Application for Planning Permission for Works or Extension to a Dwelling

Development: Single storey rear extension following removal of detached garage, erection of porch and amendments to fenestrations.
Location: 9 Well Road Pagham Bognor Regis PO21 4SR

SITE PLAN

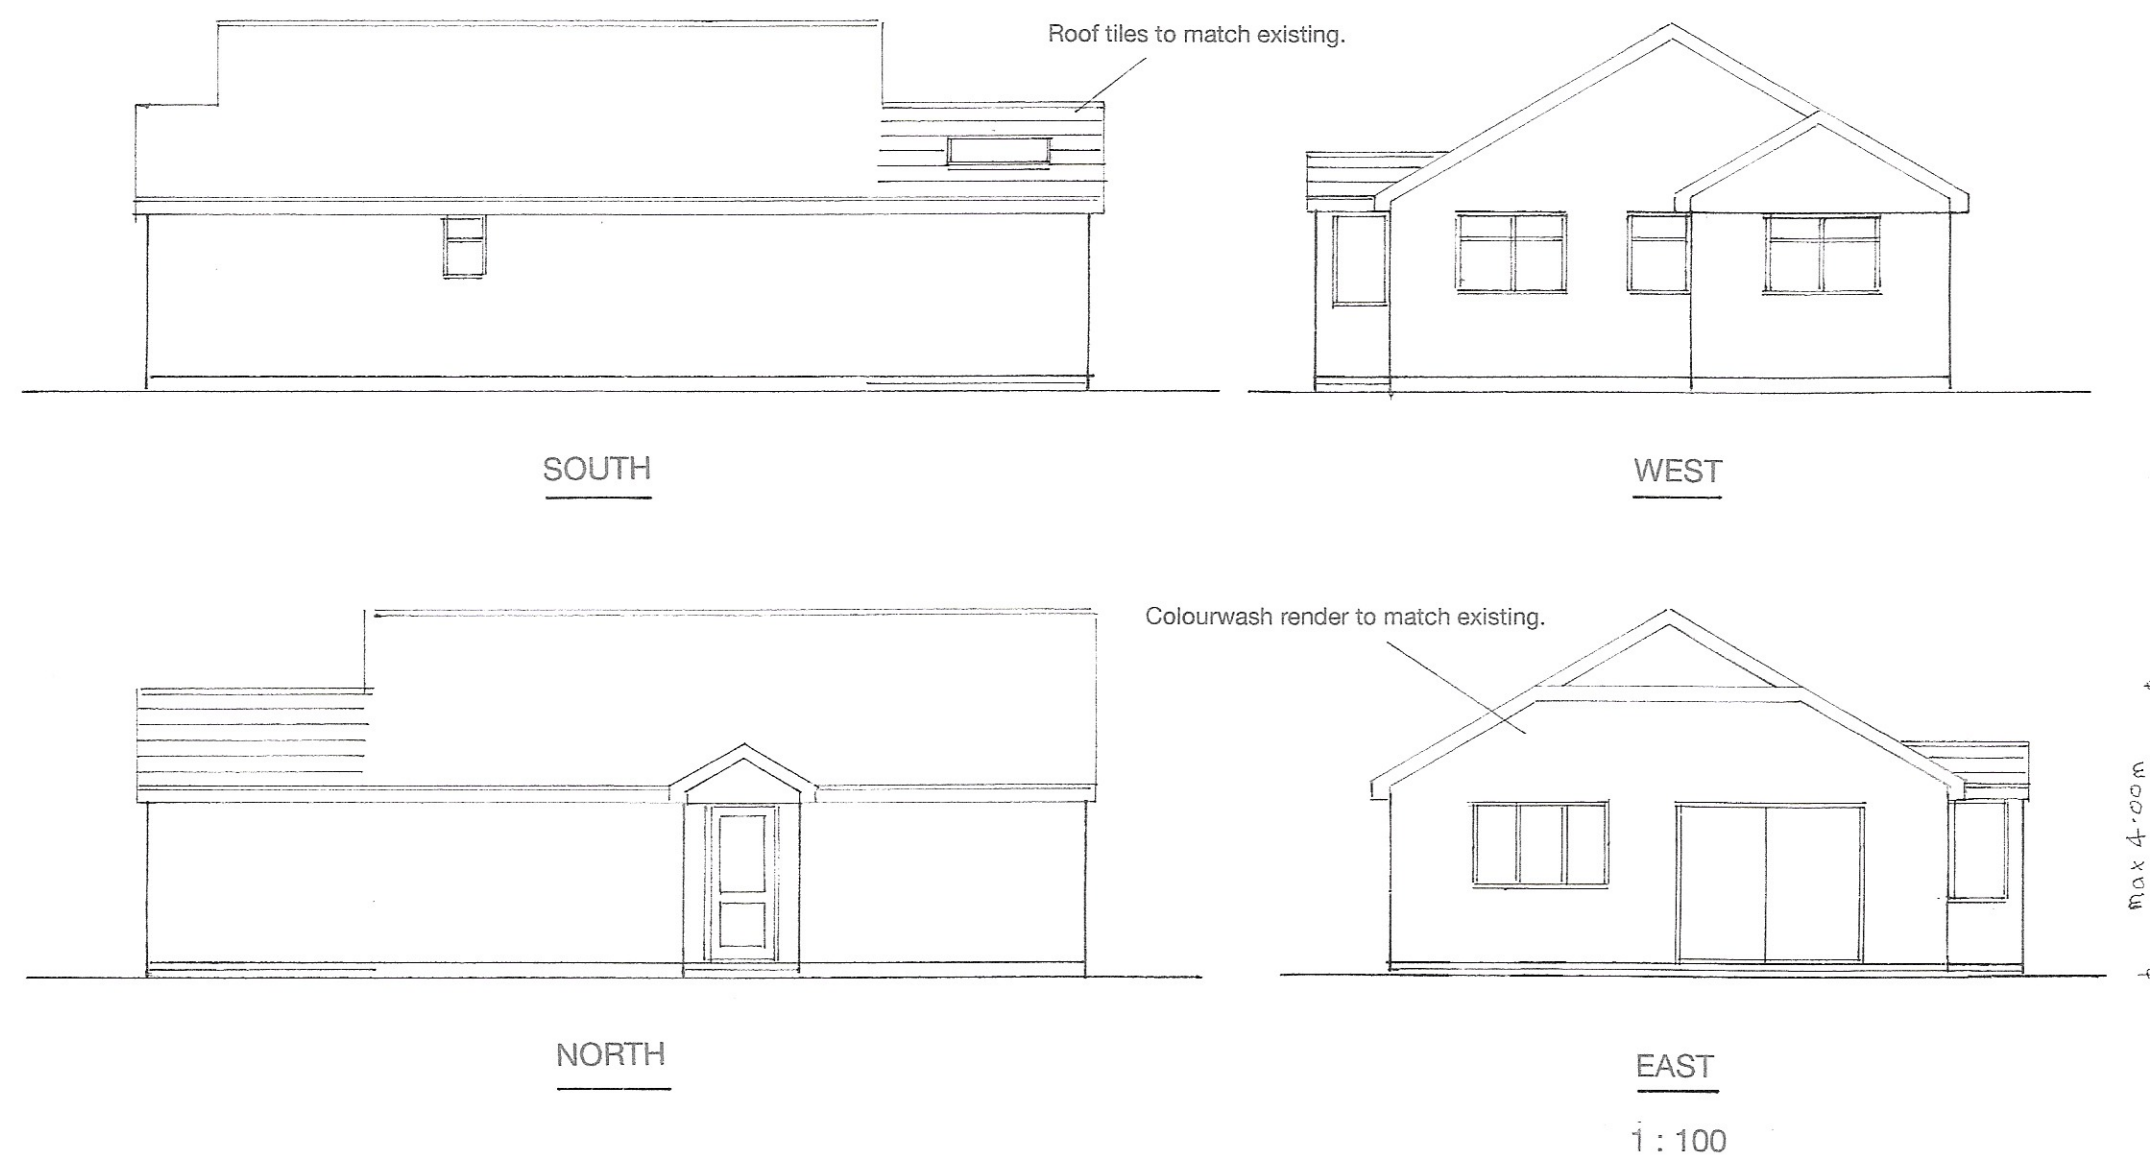
The distance you have provided to the site boundary on your block plan scales incorrectly (6.3m as 5.3m). Please amend accordingly and resubmit.
